Consultee Comments for Application 2025/92234

Application Number: 2025/92234

Address: land off Cockley Hill Lane, Kirkheaton, Huddersfield, HD5 0HH

Proposal: Variation of condition 2 (plans) on previous permission 2021/92527 for erection of 29 dwellings, formation of access, public space, attenuation and associated infrastructure

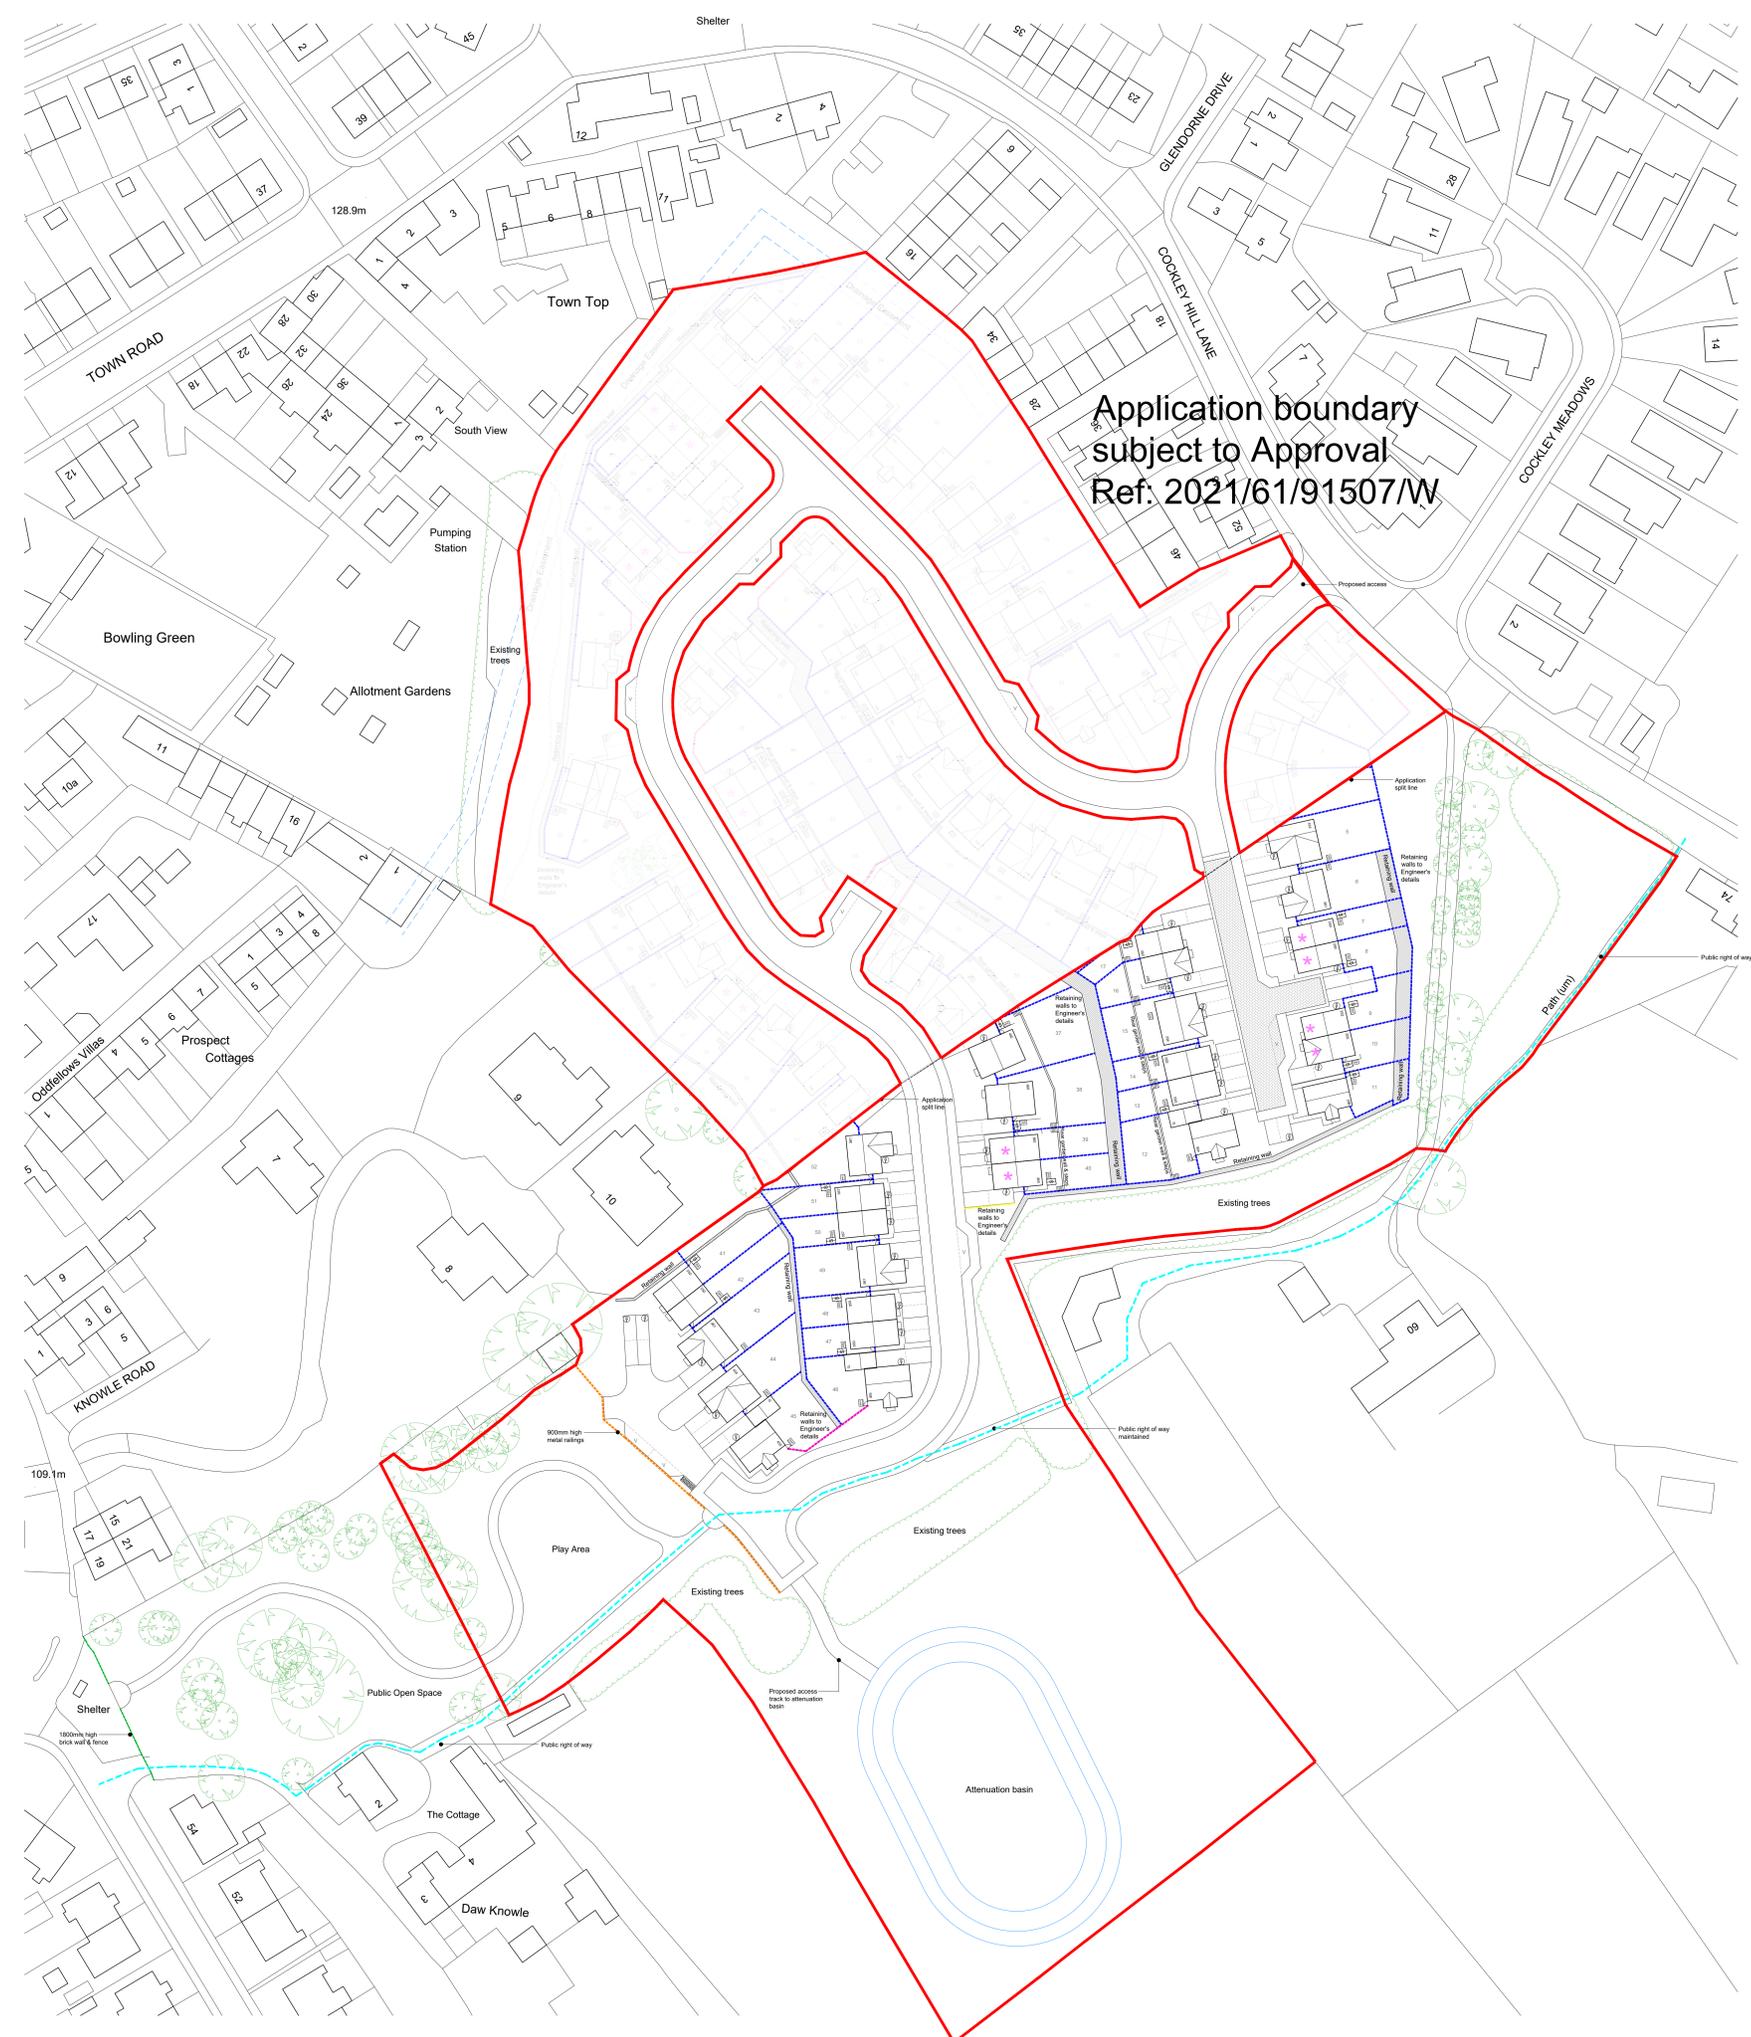
I have reviewed the Proposed Site Layout plan (Ref: 1187-EA-A-P201-B) dated 14.07.25. I cannot locate any safety measures around the attenuation basin. Can the applicant confirm that a railing or fencing will be installed for child safety. This should be at least 1.1m high, be of design which will hinder climbing and have lockable access points.

I cannot see a house type drawing for 455 (plots 12, 45 and 46) amongst the available documents. Could this be provided so I can confirm that parking provision for plots 44 and 45 is overlooked.
